Our Reference: SYD17/01699/03 (A25261357)
DP&E Reference: SSD 8865

REDEVELOPMENT OF ST ANTHONY OF PADUA CATHOLIC SCHOOL – 125-165 TENTH AVENUE AND 140-170 ELEVENTH AVENUE, AUSTRAL

Roads and Maritime has reviewed the submitted application and requests the following information for further assessment of this application:

TITLE				
ELEVENTH AND FOURTH AVENUE INTERSECTION				
SCALE AS SHOWN	DRAWN M.D.	DESIGNED M.D.	CHECKED L.S.	APPROVED M.C.
JOB No. 5914002		DRAWING No. SK-04		ISSUE 01
DATE SEPT. 2019		STATUS DEVELOPMENT APPLICATION

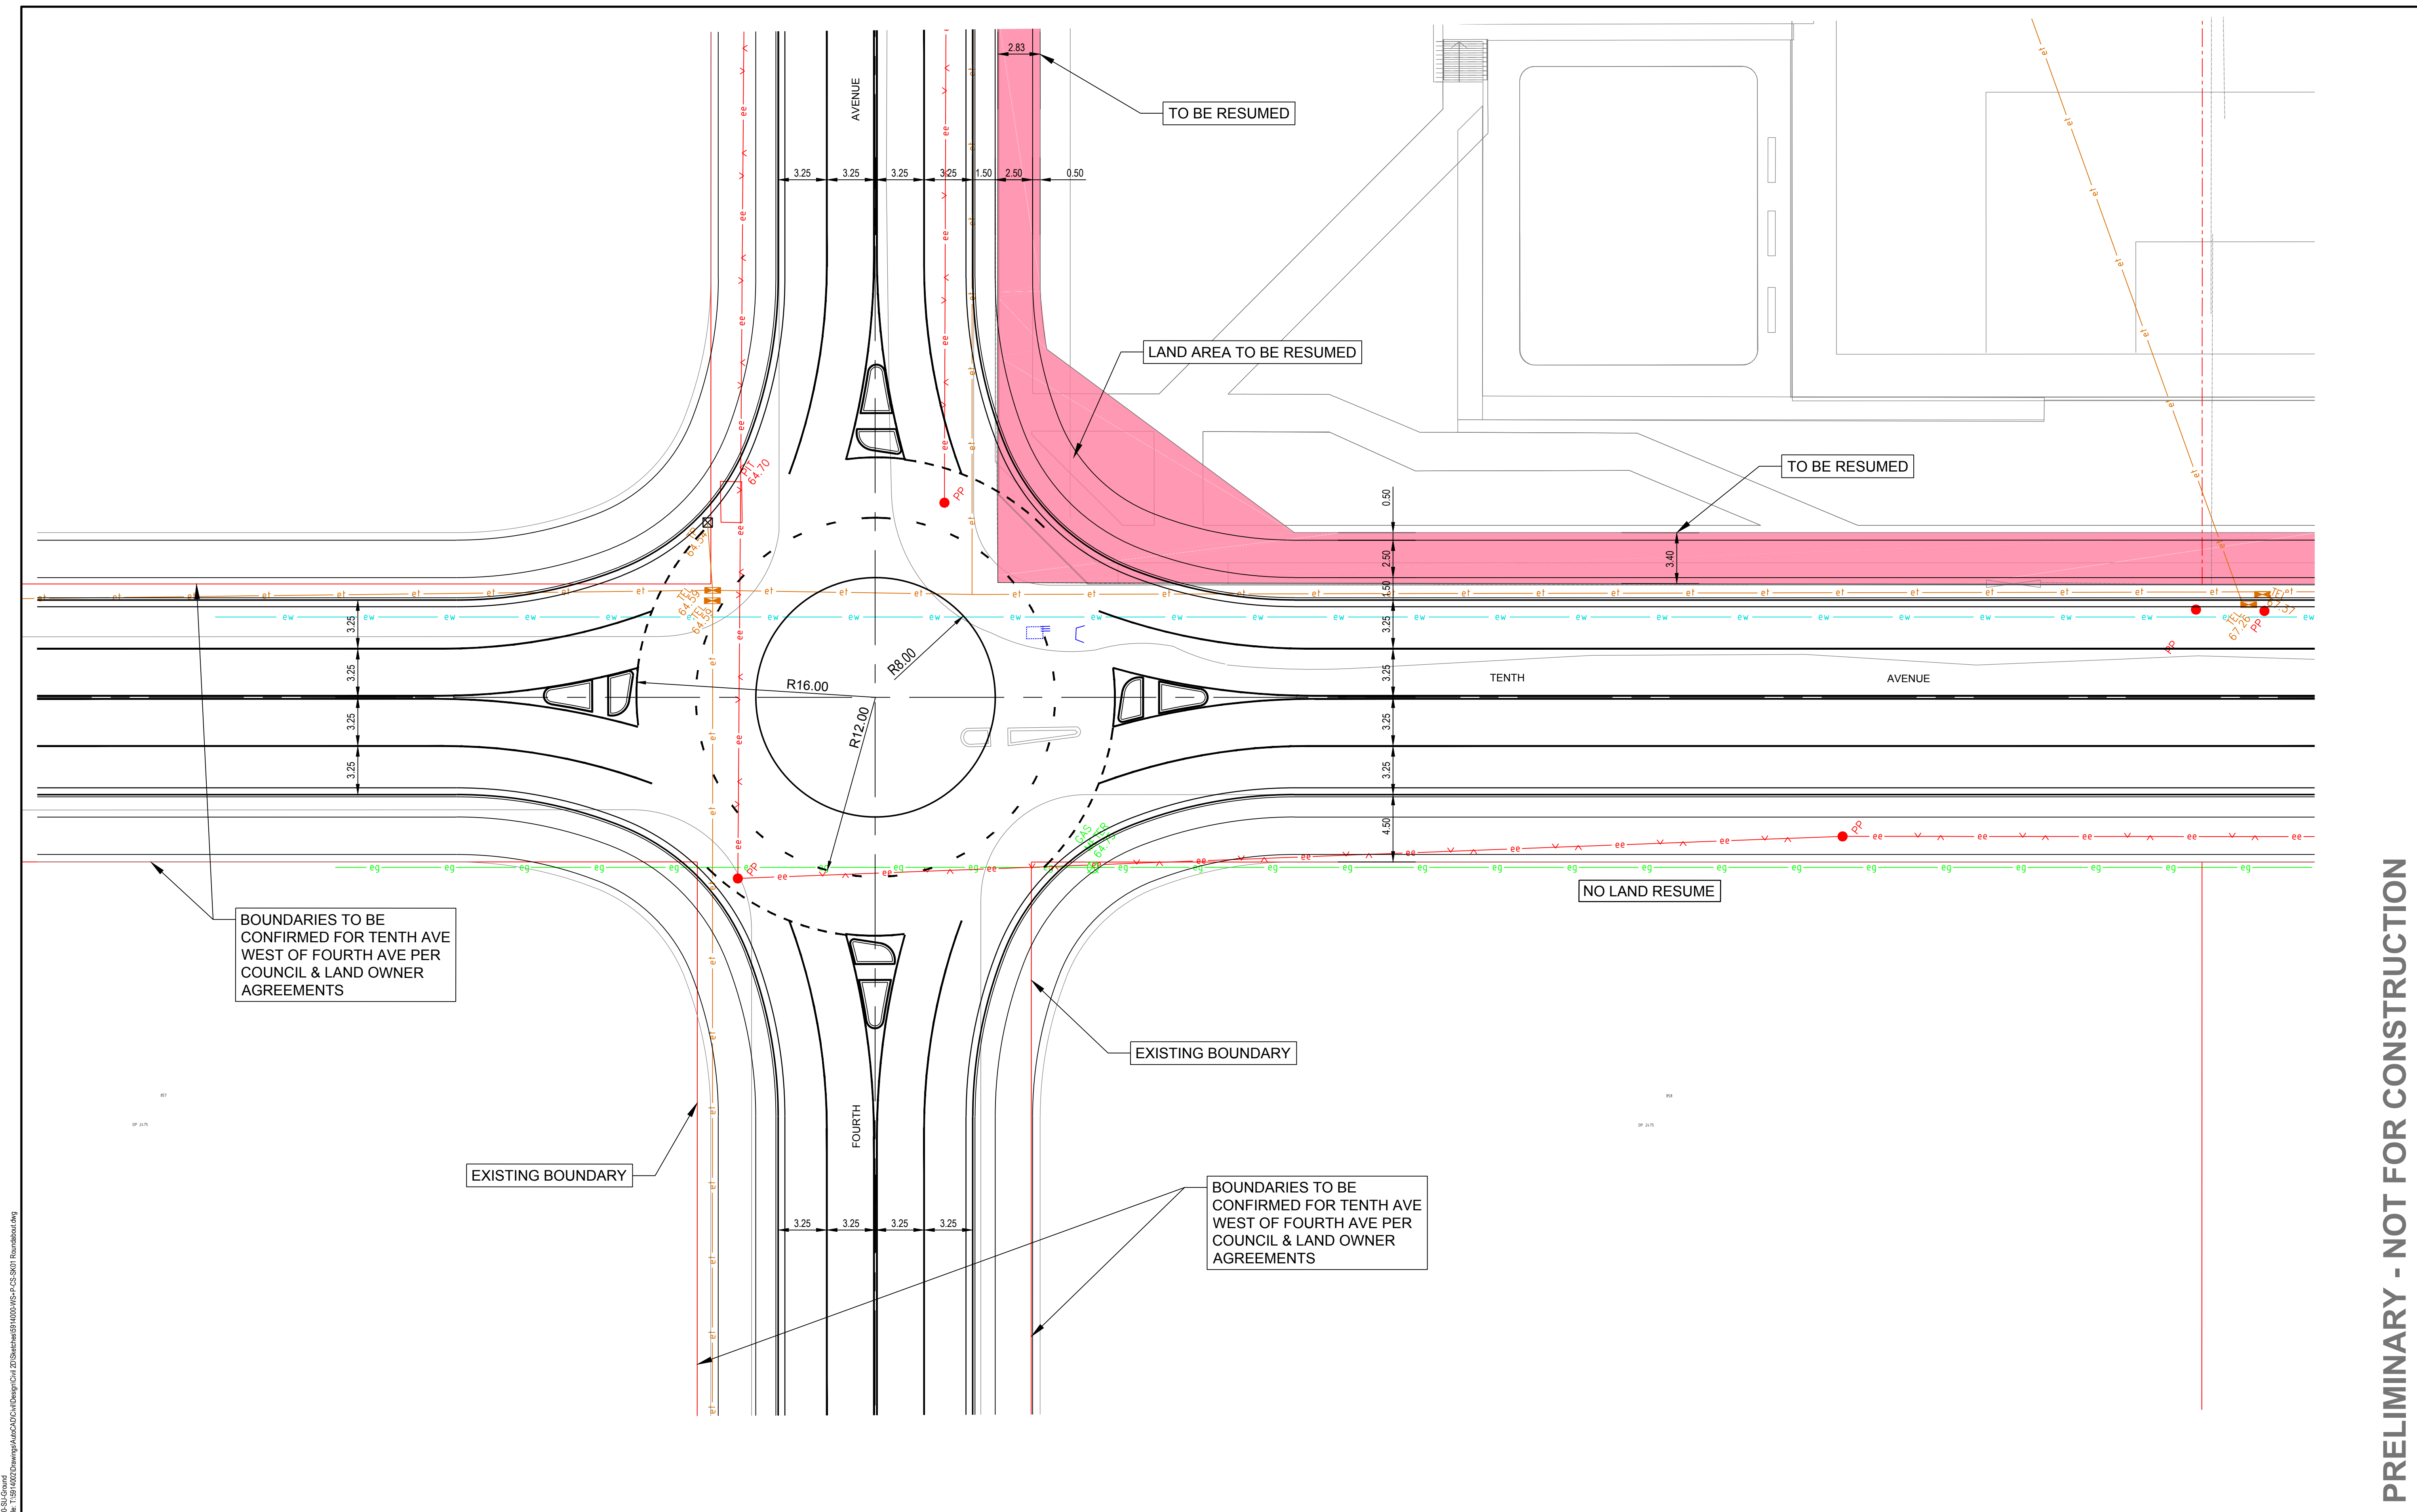
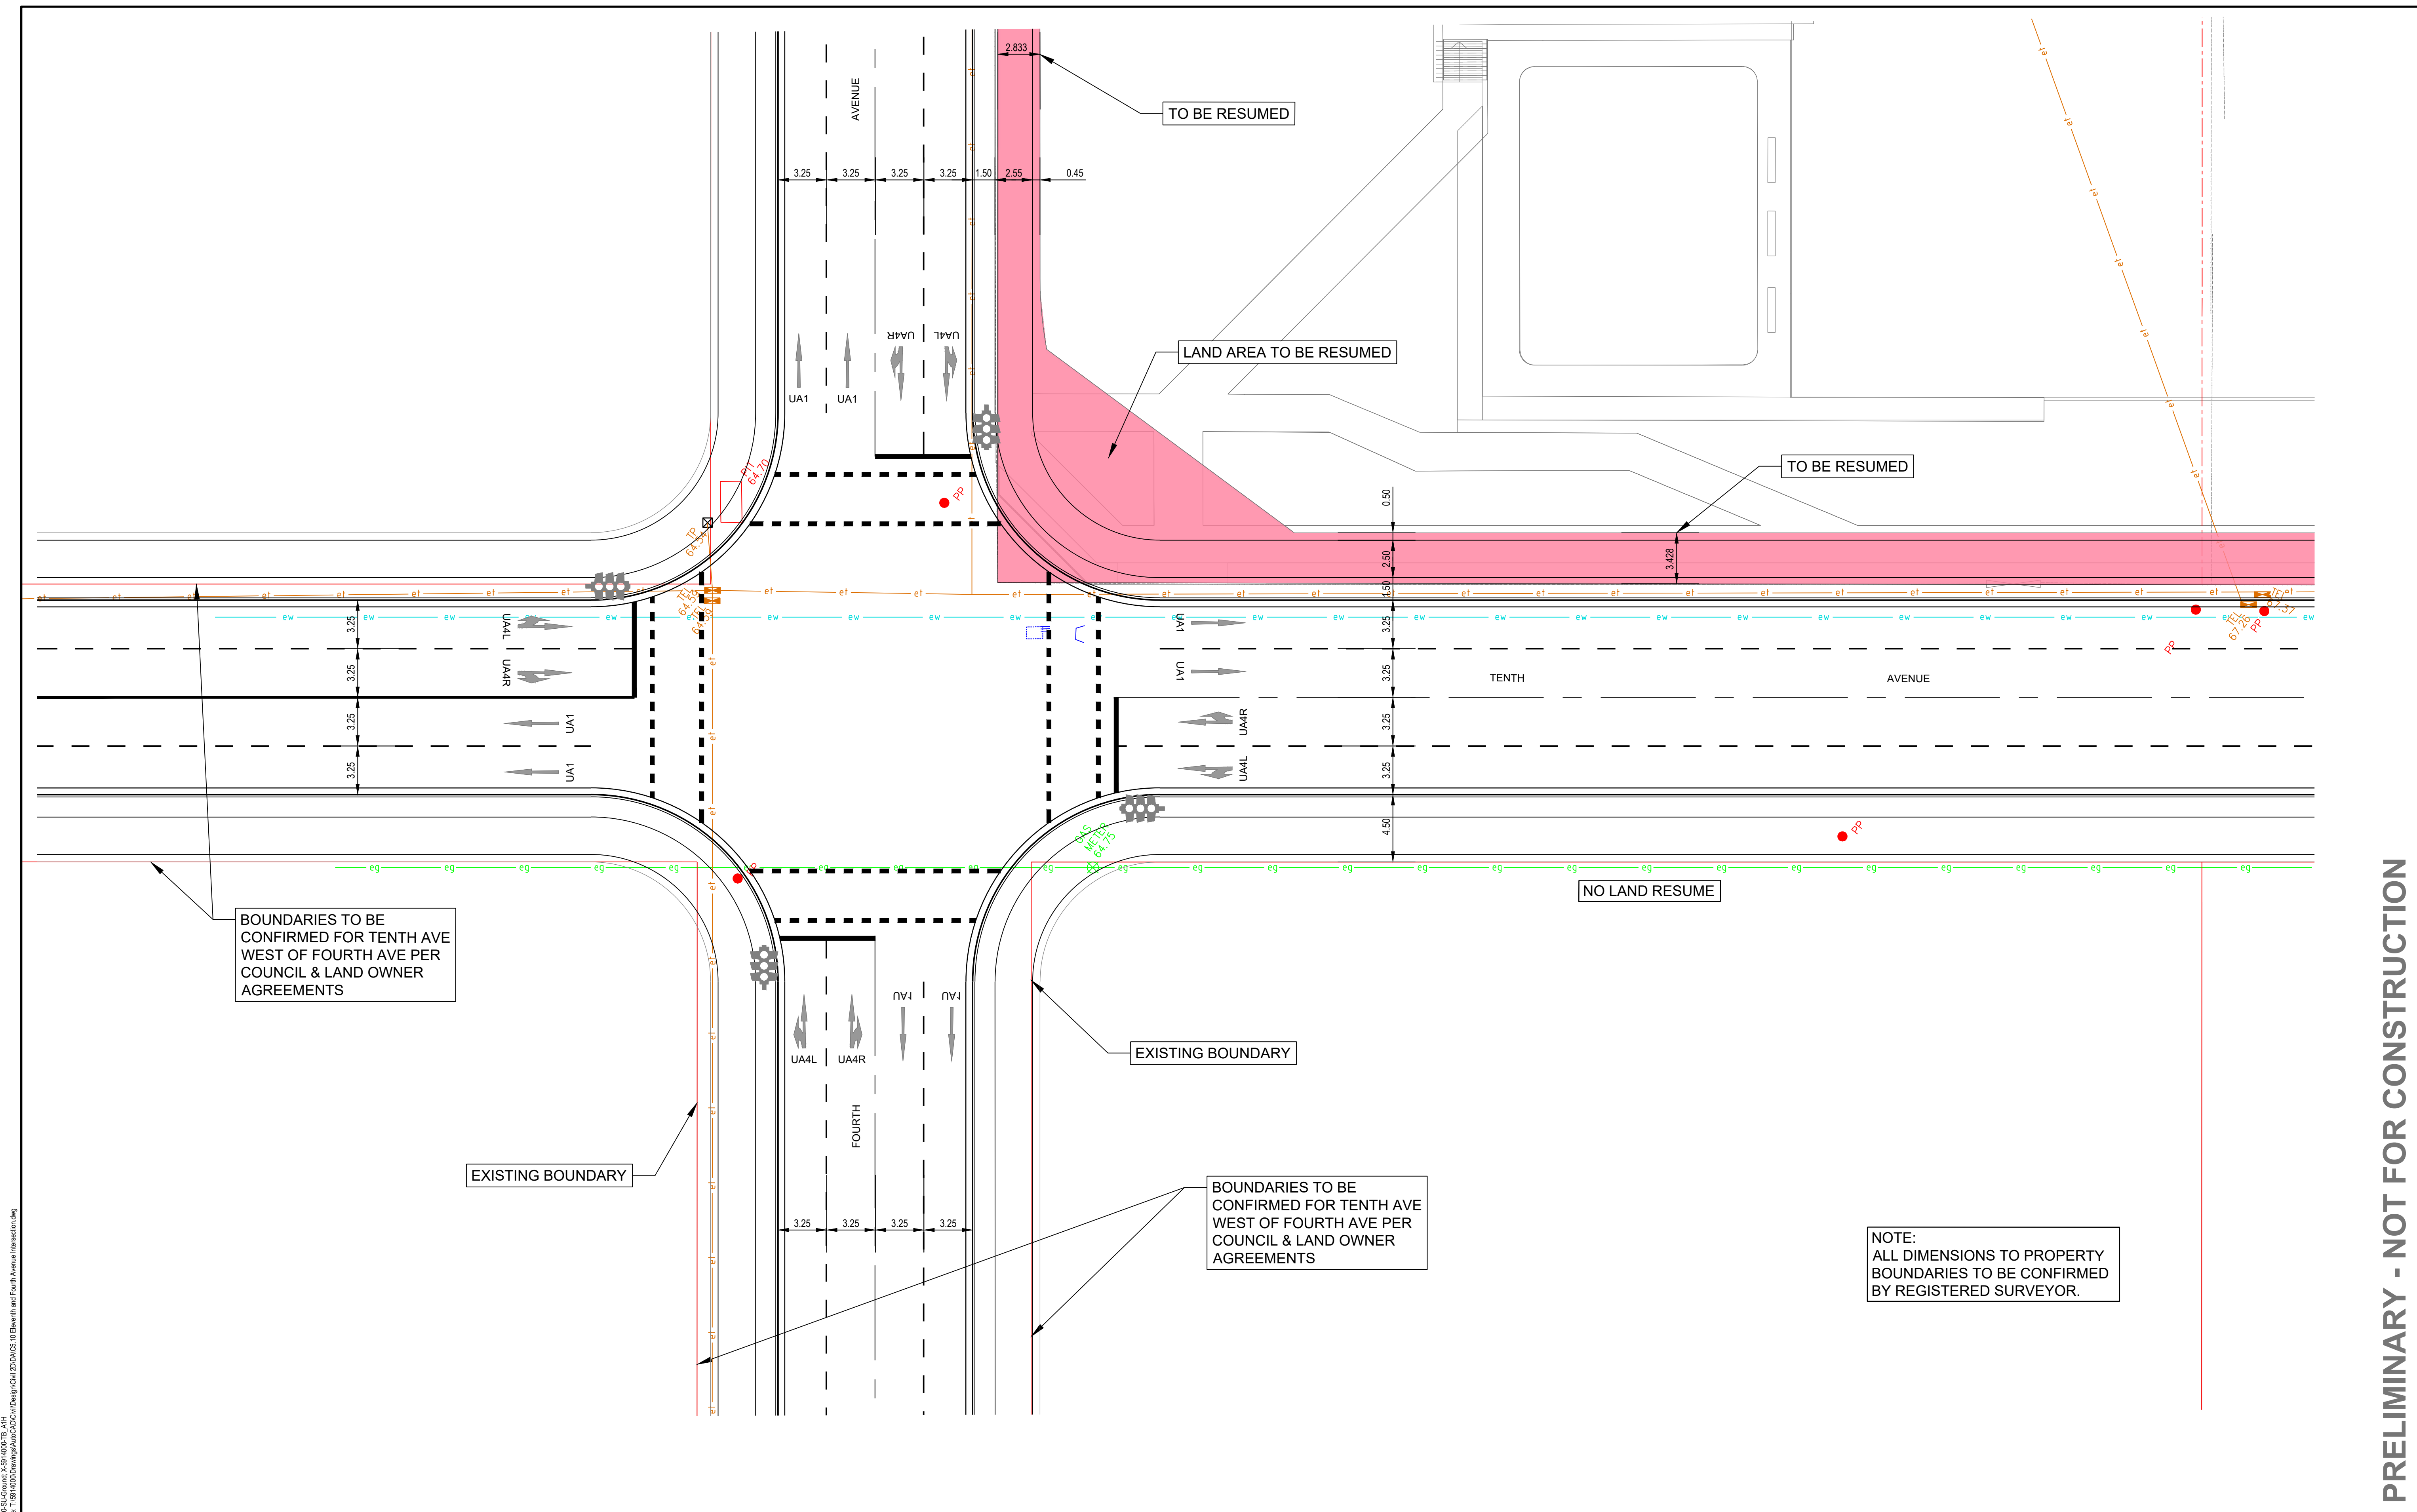
1. Roads and Maritime does not provide approval under Section 87 of the *Roads Act 1993* to the installation of traffic signals at the Fourth Avenue/Eleventh Avenue and Fourth Avenue/Tenth Avenue intersections as part of this application. It is not clear what the proponent's justifications are for the proposed traffic signals and whether warrants have been met in accordance with Traffic Signal Design Manual Section 2 – Warrants.

If the site satisfies the warrants, it does not necessarily mean that a traffic control light is the best solution. All traffic data should be analysed and alternative treatments considered to determine the optimum solution.

An alternative intersection treatment/design will need to be considered by the proponent to efficiently and safely manage vehicle and pedestrian traffic, subject to Council's satisfaction.
